KIRKLEES METROPOLITAN COUNCIL INVESTMENT & REGENERATION SERVICE

DELEGATED DECISION TO DETERMINE PLANNING APPLICATIONS

Reference No:	2026/62/90930/E
Site Address:	349, Whitehall Road, Wyke, BD12 9DP
Description:	Demolition of existing garage and erection of single storey side and two storey side and rear extensions
Recommending Officer:	Jennifer Booth

OFFICER REPORT

Proposed Other Side Elevation
Scale 1:50@A1

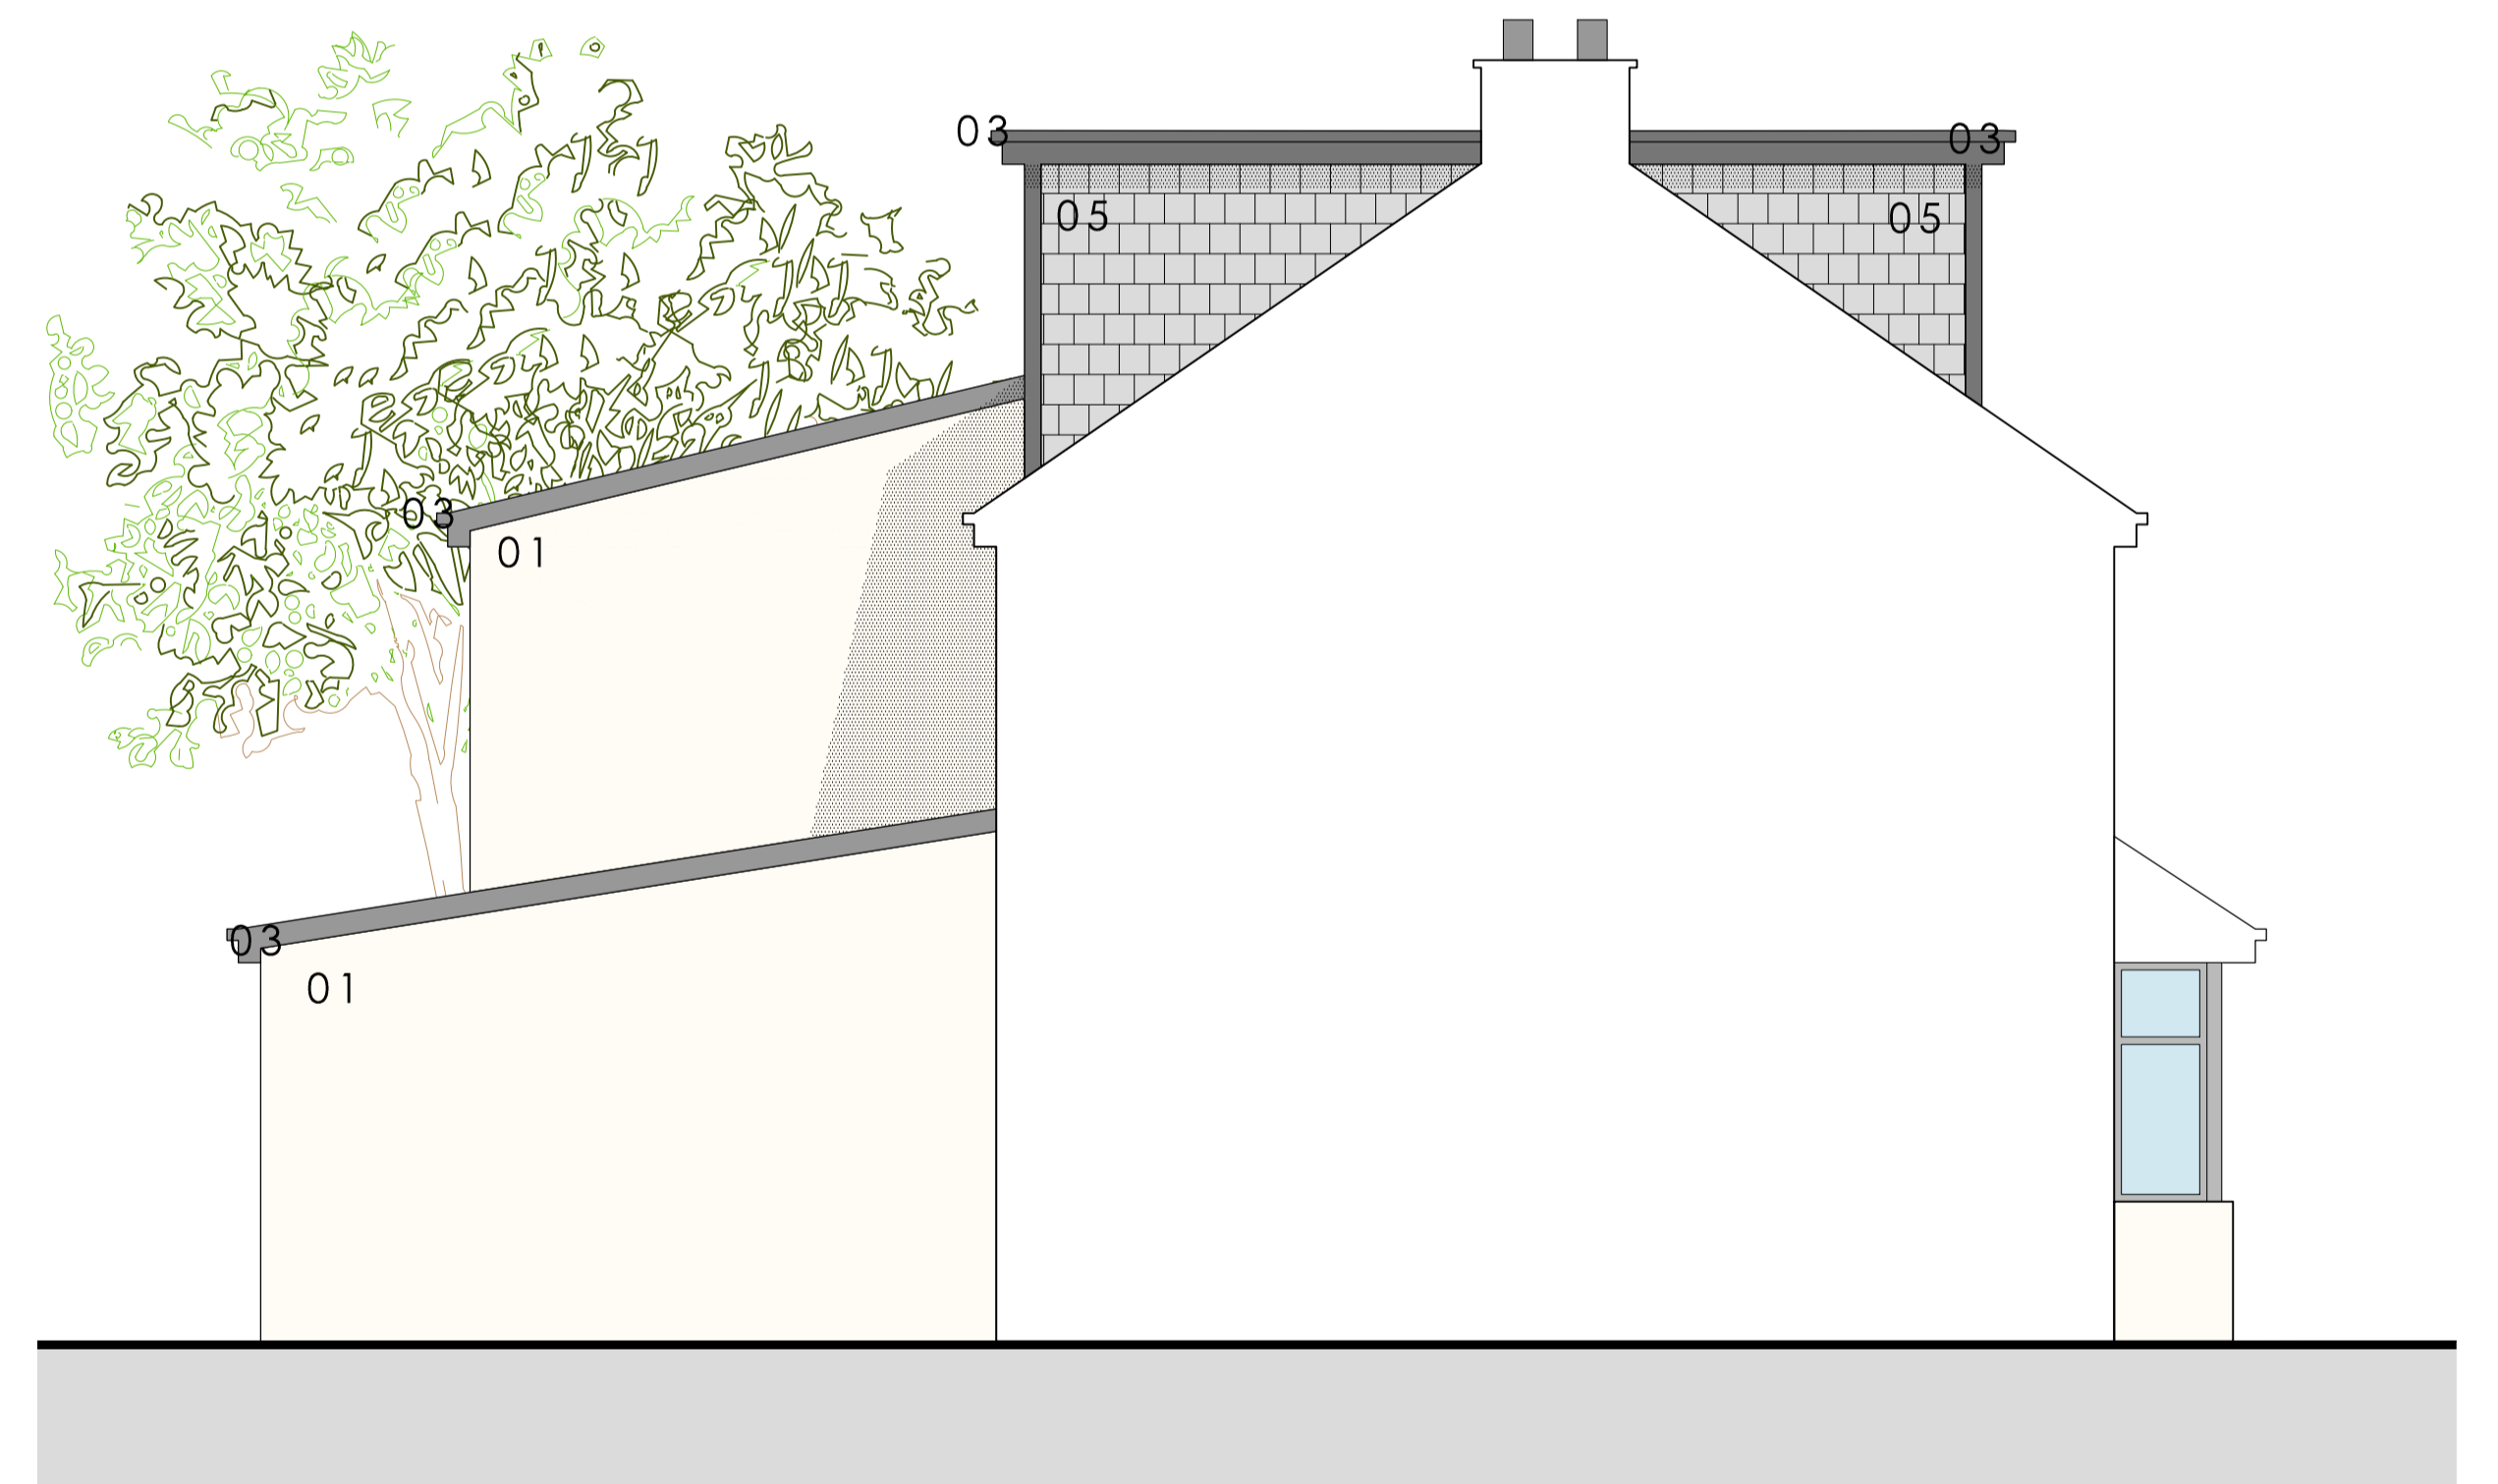
The proposed side extension incorporates a set back and set down from the main dwelling, which assists in achieving a clearly subservient form of development. When considered cumulatively alongside the other elements of the scheme, the overall proposal now appears appropriately subordinate and successfully respects the character and proportions of the host dwelling. In particular, the revised roof form, including the adjusted rear roof plane, results in a balanced and coherent relationship with the main house, integrating well within the overall composition. The proposed use of render and tiles is considered acceptable and, when taken together with the improvements to the scale, form and design, ensures that the development preserves the character and appearance of the host dwelling and makes a positive contribution to the wider streetscene.

The proposed rear extension, comprising both single and two-storey elements, would project approximately 4.9 metres at ground floor level, reducing to 3.5 metres at first floor. While this extends beyond what might typically be supported, the variation in depth between the two storeys helps to break up the massing and results in a form of development that remains proportionate to the host dwelling. The design approach ensures that the extension integrates effectively with the existing property. Furthermore, the roof form contributes positively to the overall composition, adding visual interest and creating a cohesive and balanced appearance. The use of materials is considered appropriate and, when combined with the scale, form and design of the proposal, ensures that the extension reads as a well-considered and subservient addition that preserves the character and appearance of the main house.

The ground floor of the rear extension would be constructed up to the shared boundary with an increased projection over the existing single storey. It is noted that the neighbour also has their own single storey rear extension and the increased potential for overshadowing and overbearing is limited. The first floor would be set away from the shared boundary limiting the potential for overshadowing or overbearing. The windows proposed would look into the applicants own amenity space.

The side extension would reduce the space between the properties and the rear element would extend beyond the level of the main house. However, a gap would be retained which would reduce overshadowing and overbearing. The windows proposed would look into the applicants own amenity space.

- Out of character due to scale – **Response:** *amended plans have been received which reduce the overall scheme and retains the hipped roof style of the property.*
